Your Ref :
Our Ref : P/91/17/NMA

Application for a non- material amendment following the grant of P/125/14/PL relating to approved plans.

251 Pagham Road, Pagham, ,

FOR
CRAYFERN HOMES LIMITED
Scale : 1:100 @ A1 Date : AUG 17
Drawing No : 108_16 SK13

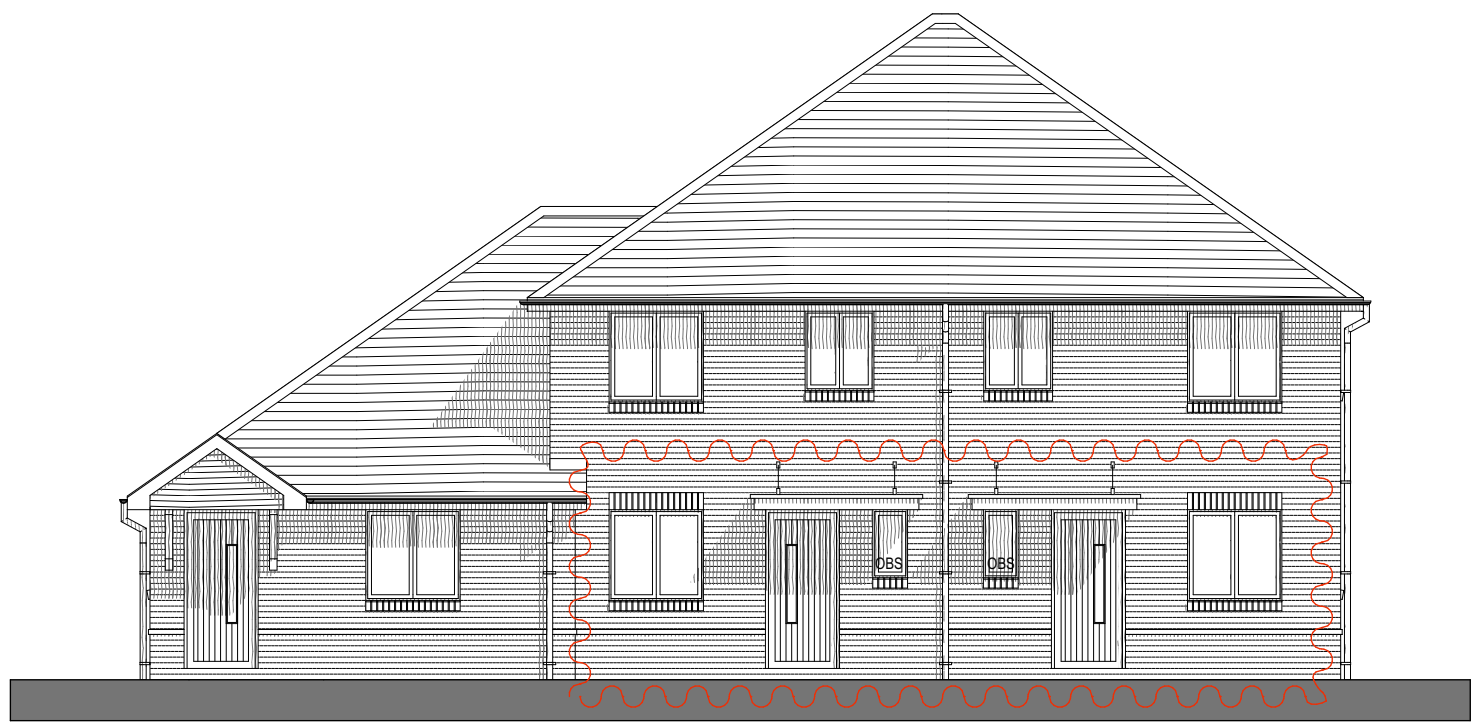
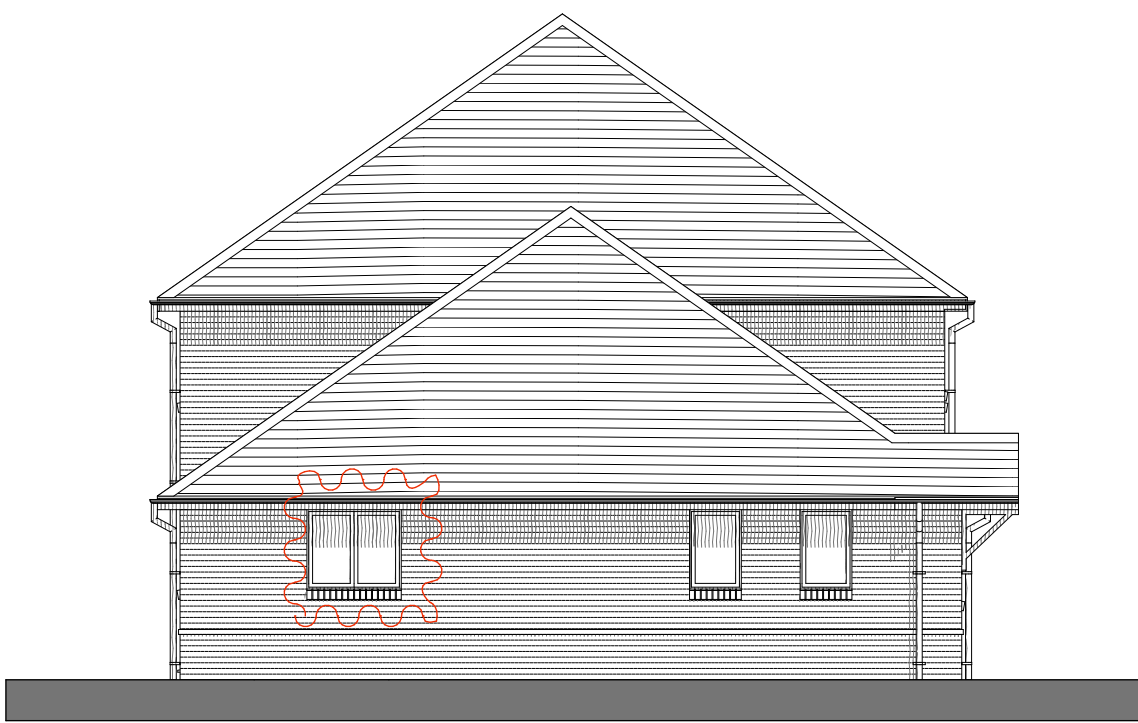
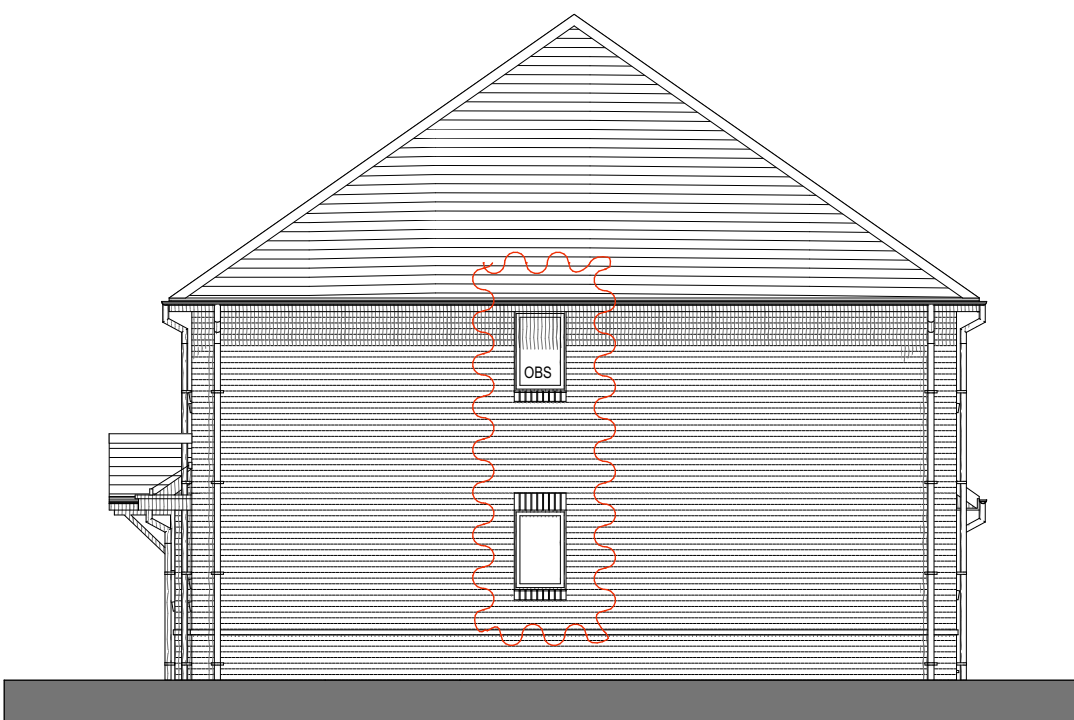
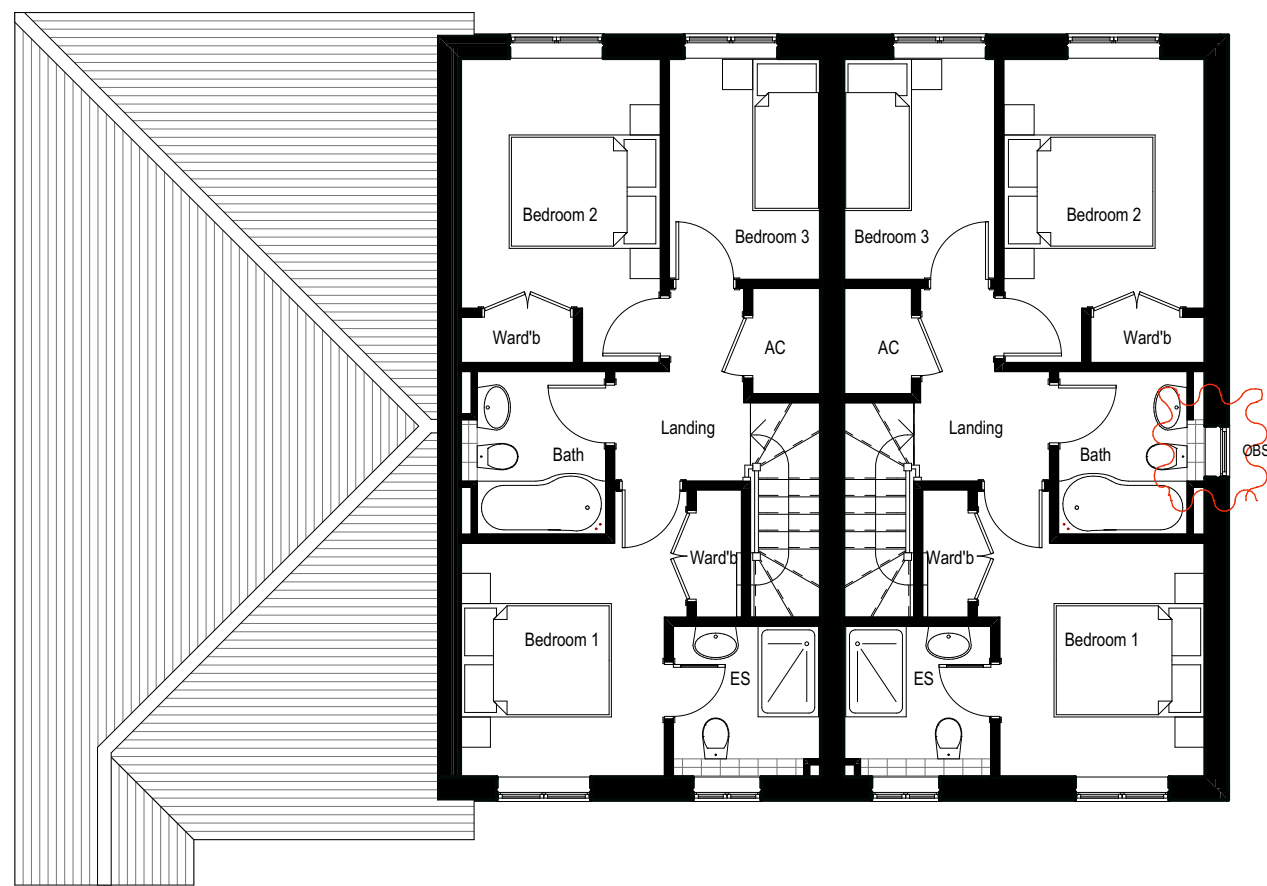
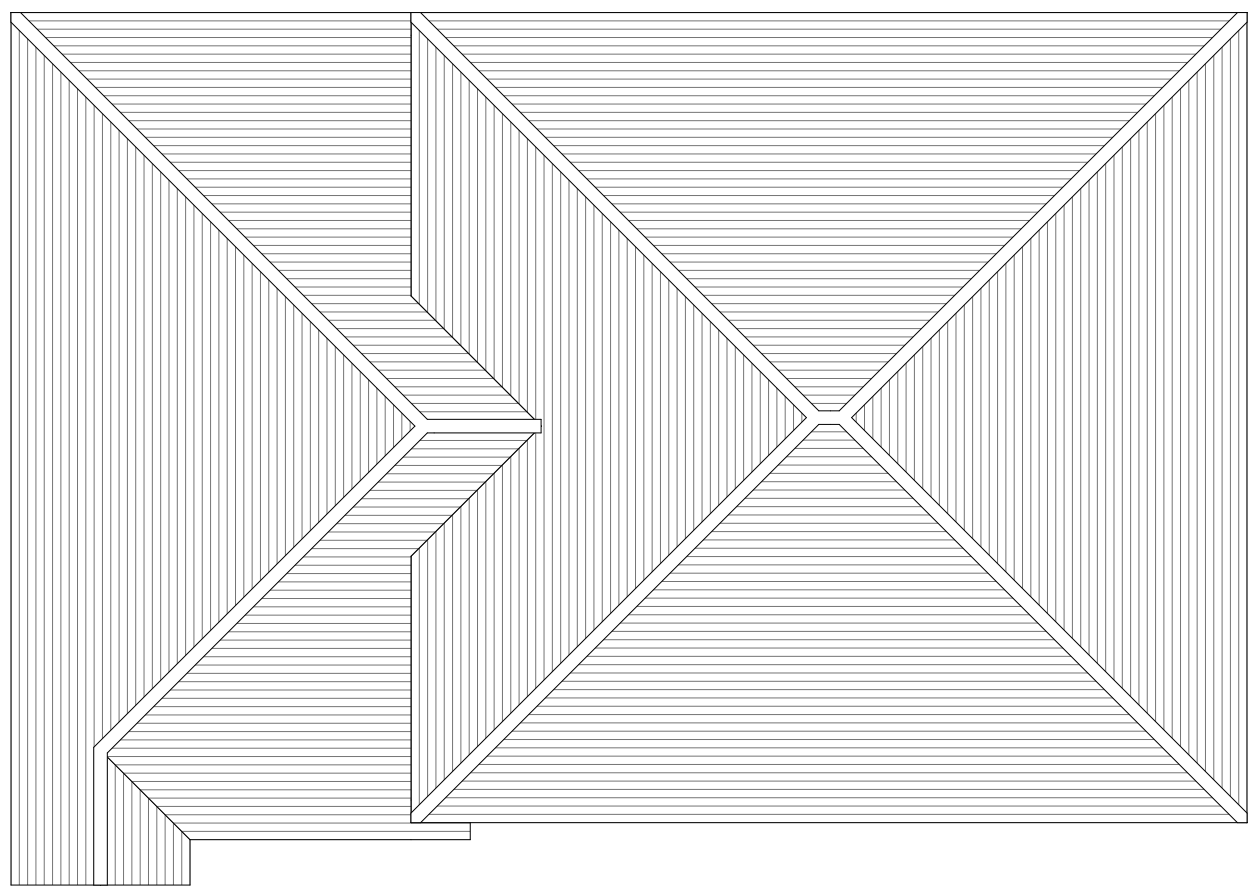
Plots 31-33 - Alterations to the design of first floor rear windows, alterations to the design of the ground floor windows & doors and alterations to the design of the ground/first floor windows to both side

elevations;

FOR
CRAYFERN HOMES LIMITED
Scale : 1:100 @ A1 Date : AUG 17
Drawing No : 108_16 SK12 Rev A

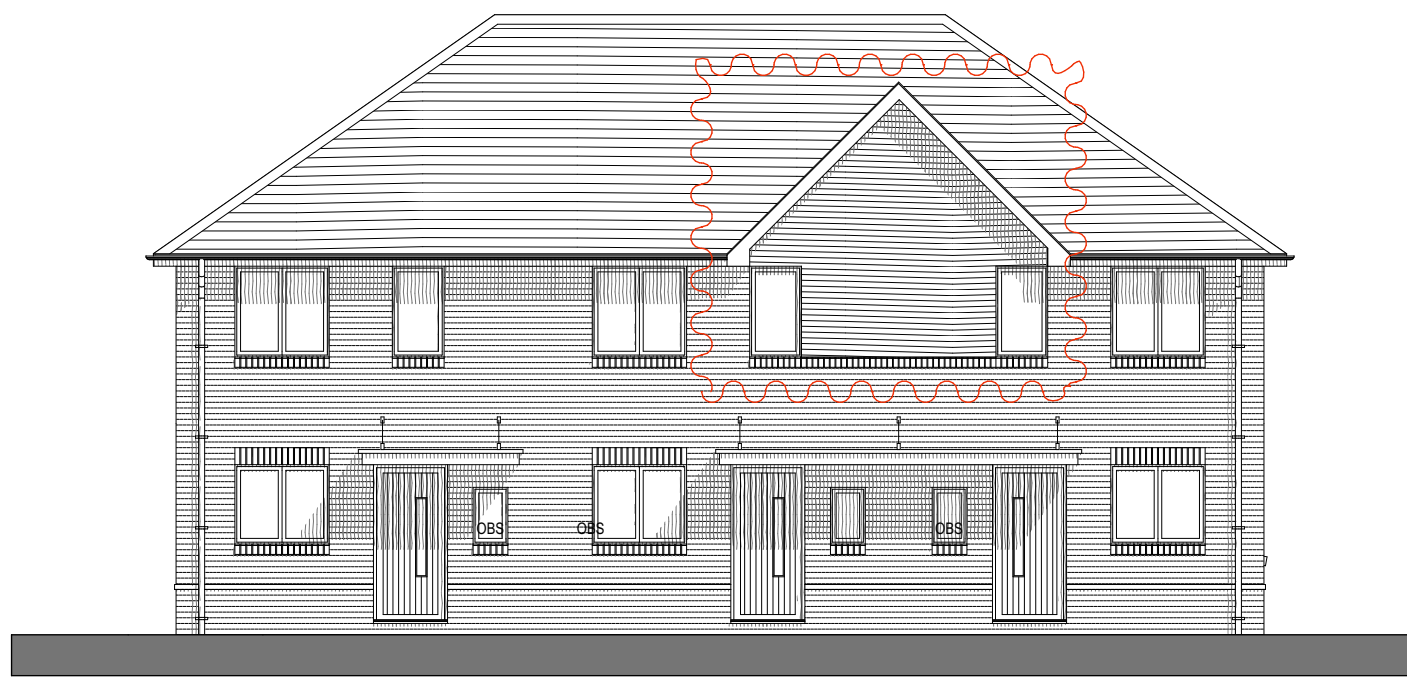
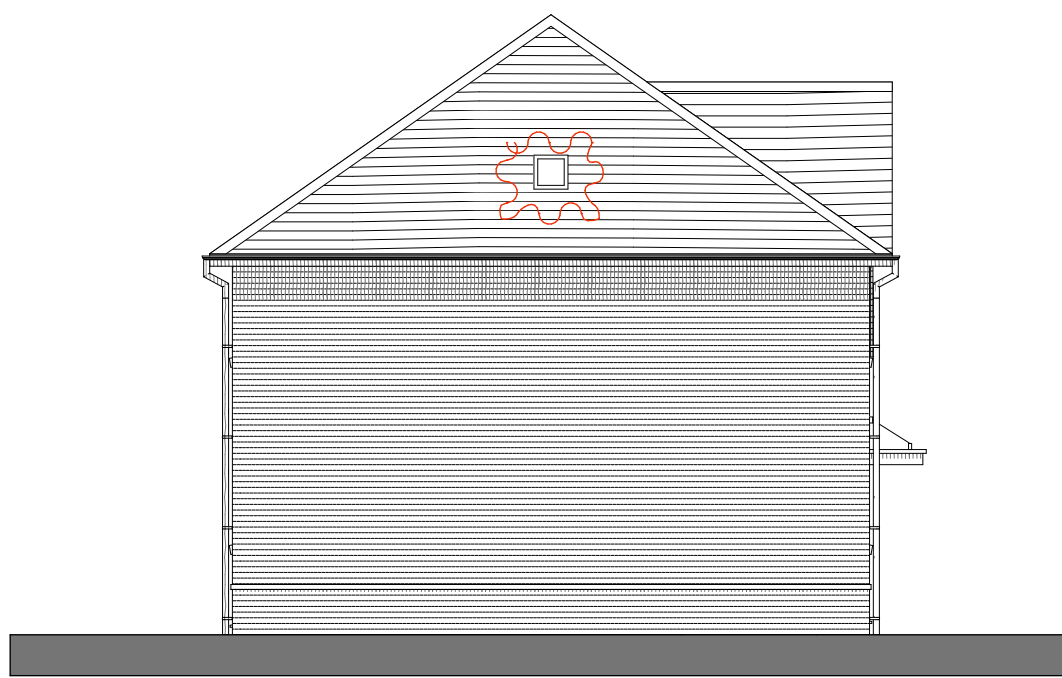
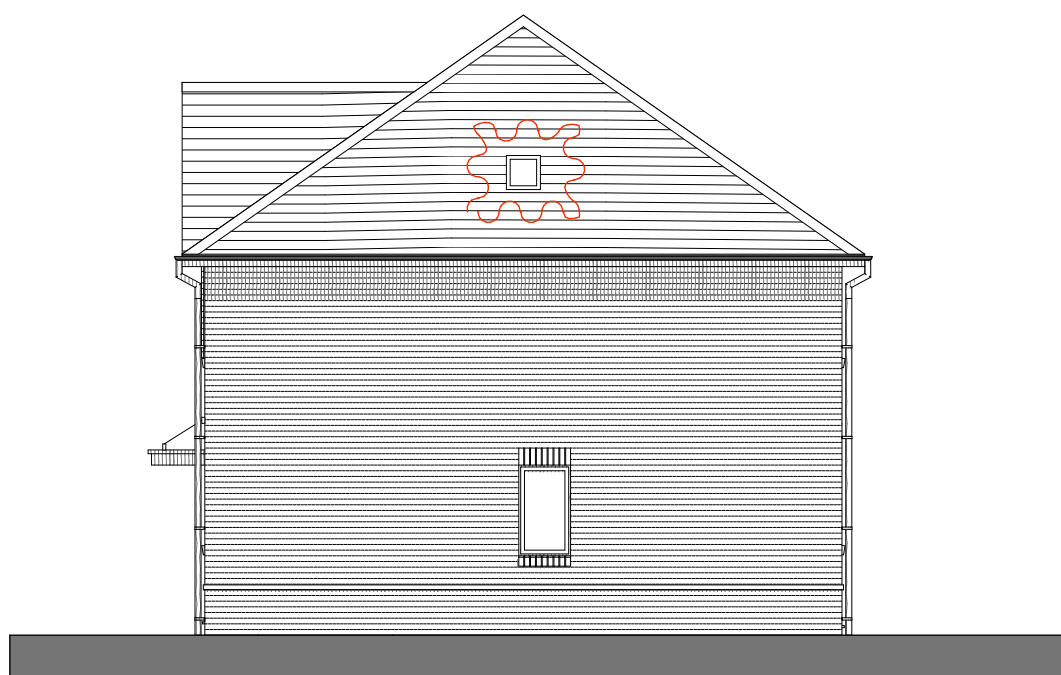
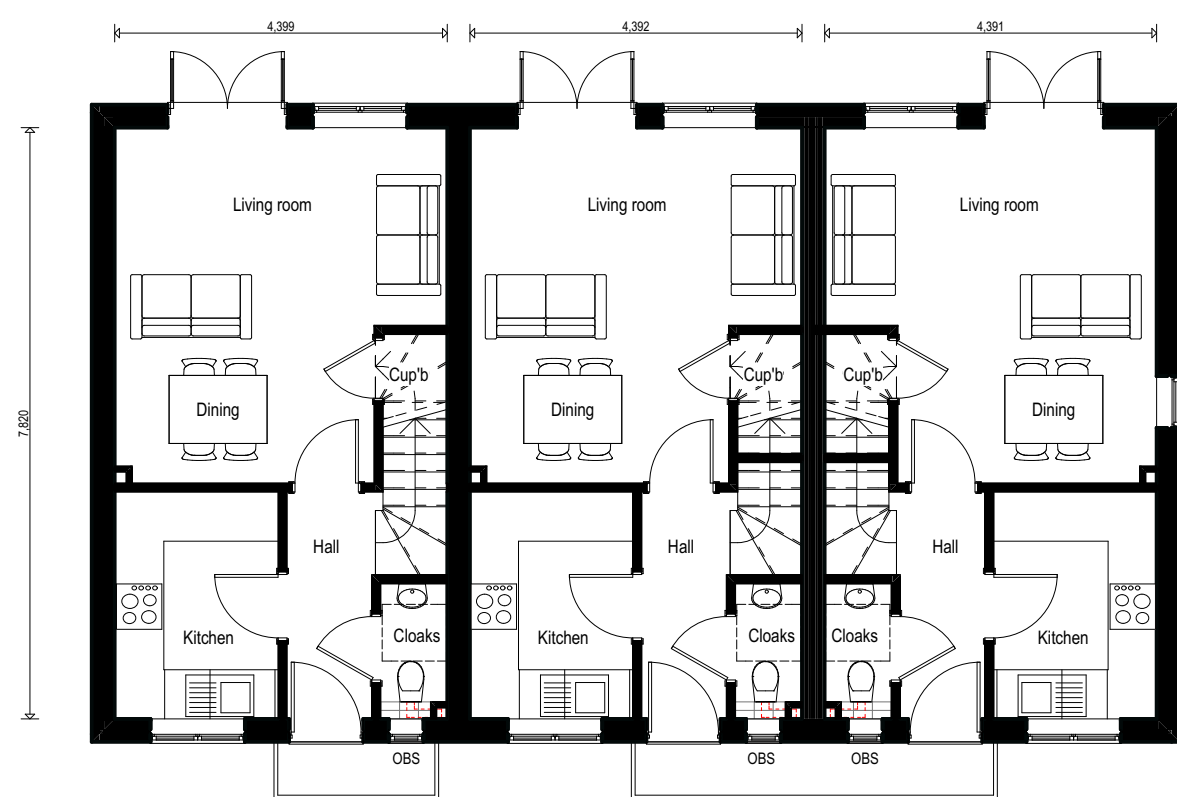
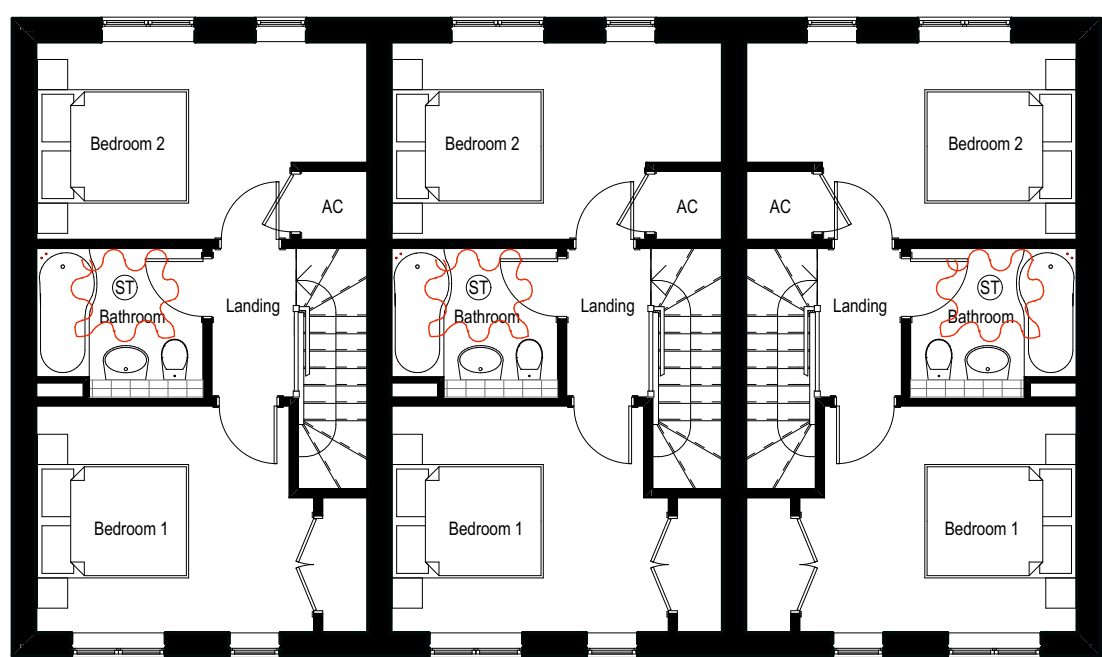
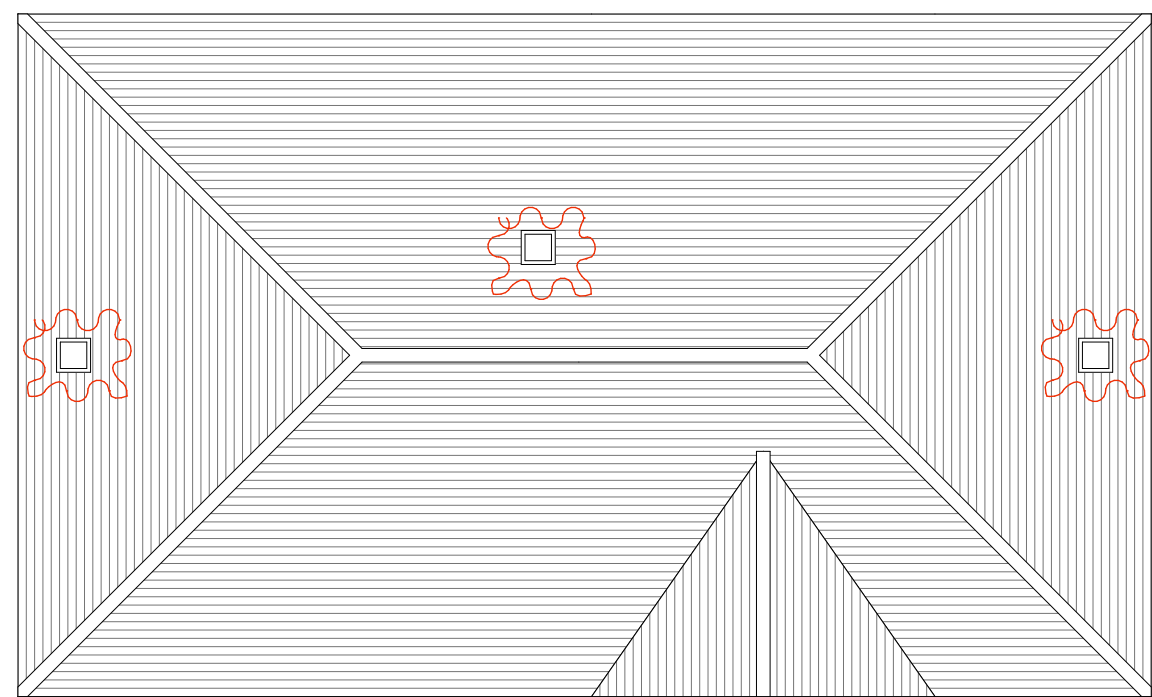
Plots 28-30 - Alteration to the materials/design of the front gable roof projection and addition of three sun tubes to the roof;
